Y/108/21/L

Stakers Farm North End Road Yapton BN18 0DU

Listed building consent for conversion of & alterations to existing barns to create 3 No. dwellings, erection of car barns & stores, a replacement pump house, demolition of barn, associated landscaping & parking (amendment to Y/106/19/L)

BARNS 1&2 PROPOSED SOUTH EAST ELEVATION

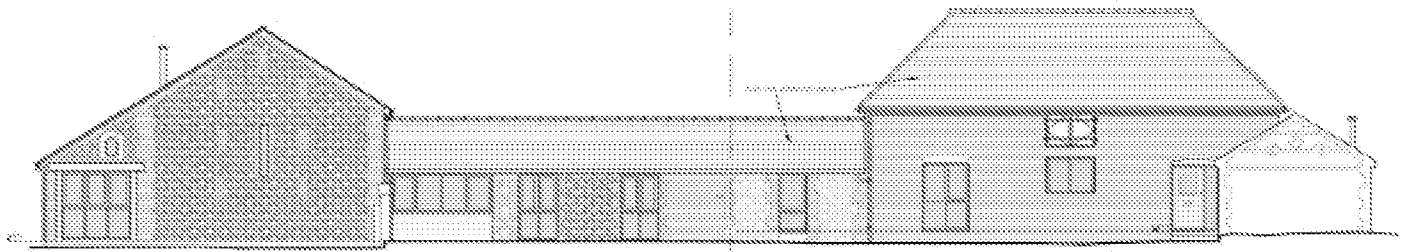
I am also concerned about the large window to be introduced to unit 2 on the South-East elevation, as well as the treatment of the existing opening for what will be bedroom three of the same unit. Further, it is not clear why the utility window of barn 2 is to be altered nor why a range of windows were chosen for the S.W courtyard elevation of barn one (when a more uniform appearance would be appropriate here). This requires clarification from the applicant, and it is suggested that more appropriate designs are prepared here.
